APPLICATION NO: SSD-6125-Mod-3 (Our Ref. 25-2015-8-3)

PROPOSAL: Cabbage Tree Road Sand Quarry Mod 3 Extension and Amendments

PROPERTY: 398 Cabbage Tree Road, WILLIAMTOWN

Figure 1
Proposed Amendment to Cabbage Tree Road Sand Quarry and Biodiversity Stewardship Site Boundary

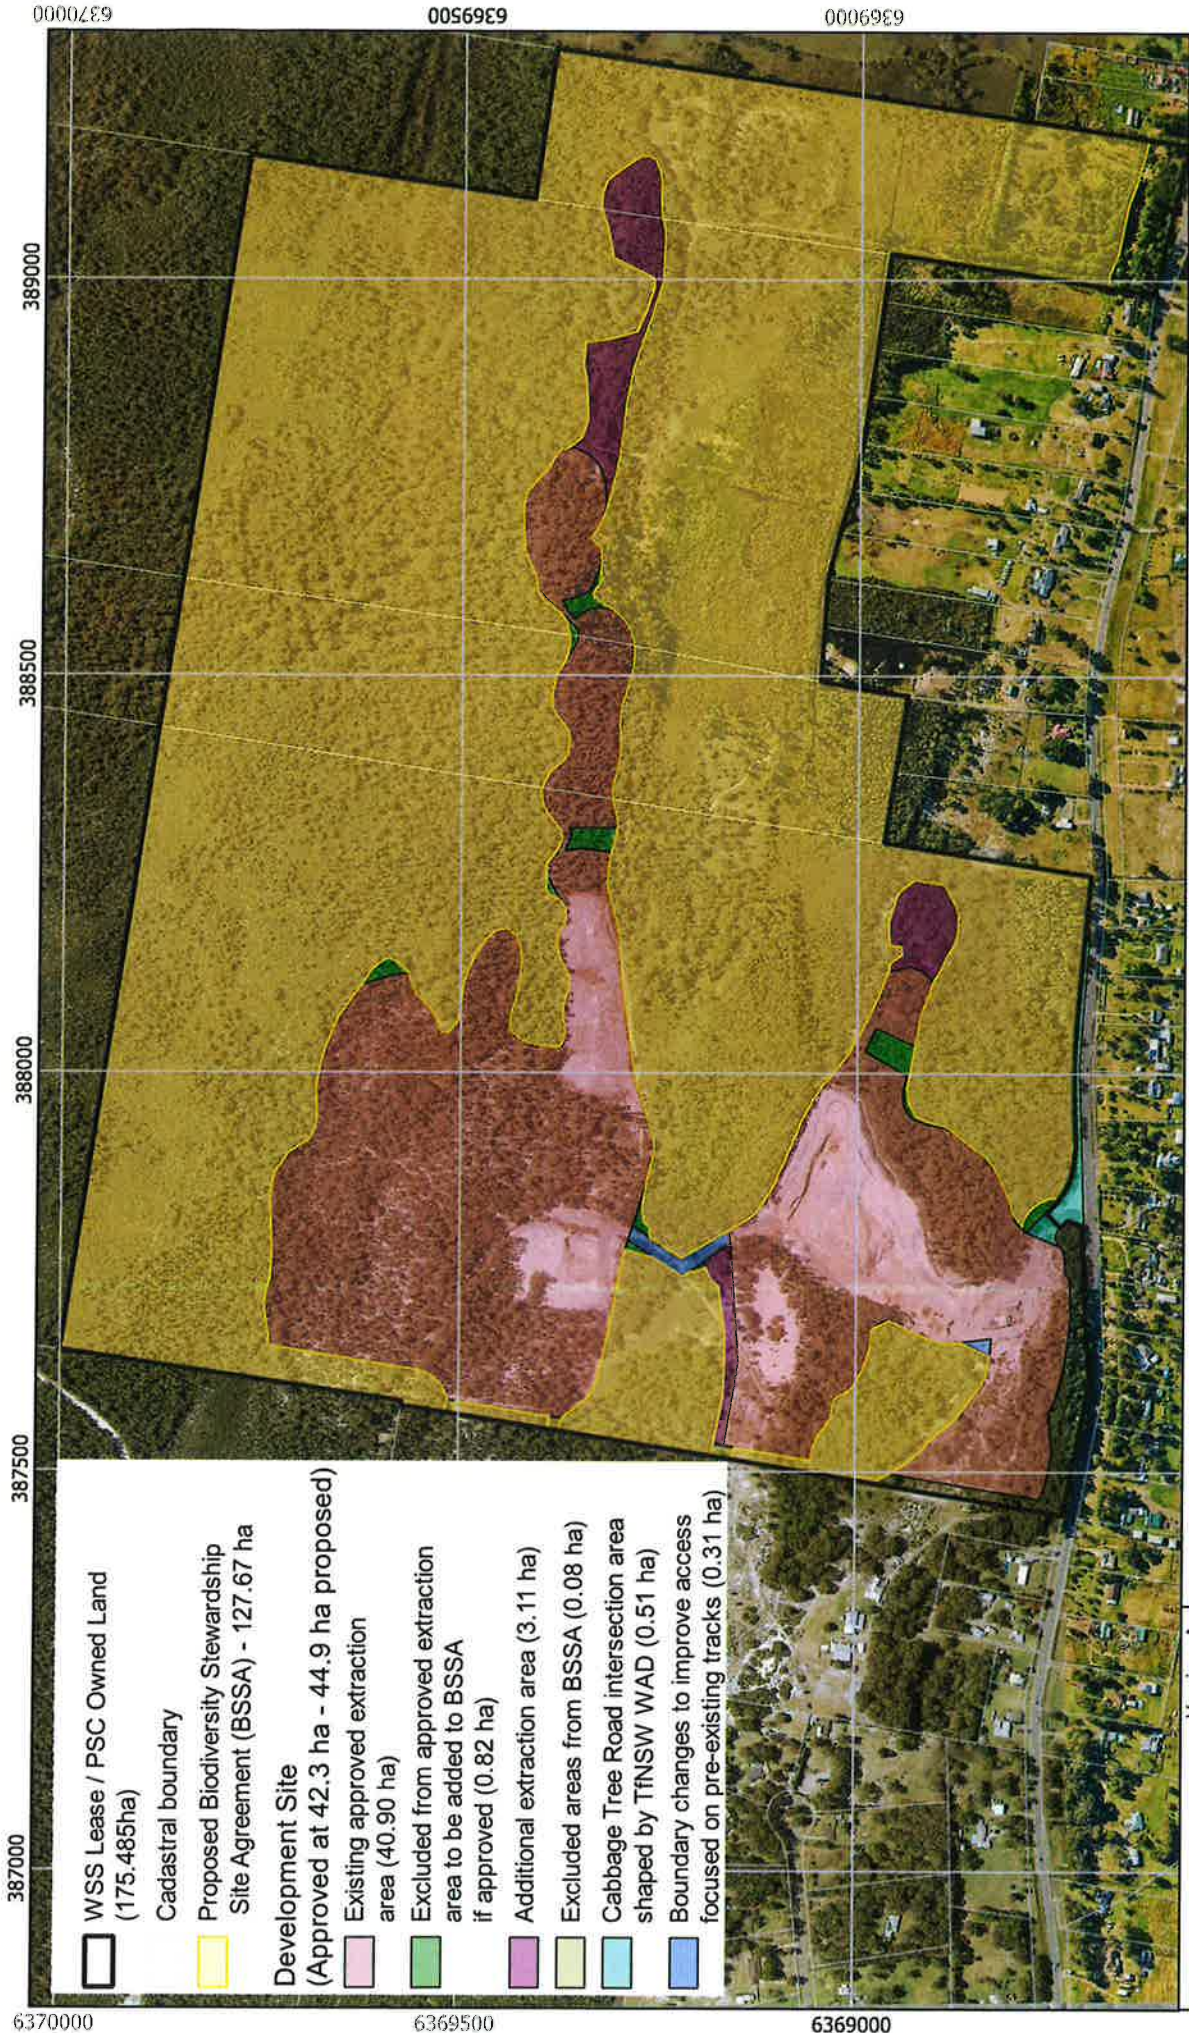
- The expanded quarry footprint in the east of the site (in the location where quadrats 1 and 2 were conducted) will have substantial impacts to Koala, Squirrel Glider, Wallum Froglet and Mahony's Toadlet. These impacts should be avoided in accordance with the requirements of the *Biodiversity Conservation Act 2016*.
- The BDAR is not signed by the BAM accredited assessor and is currently invalid.
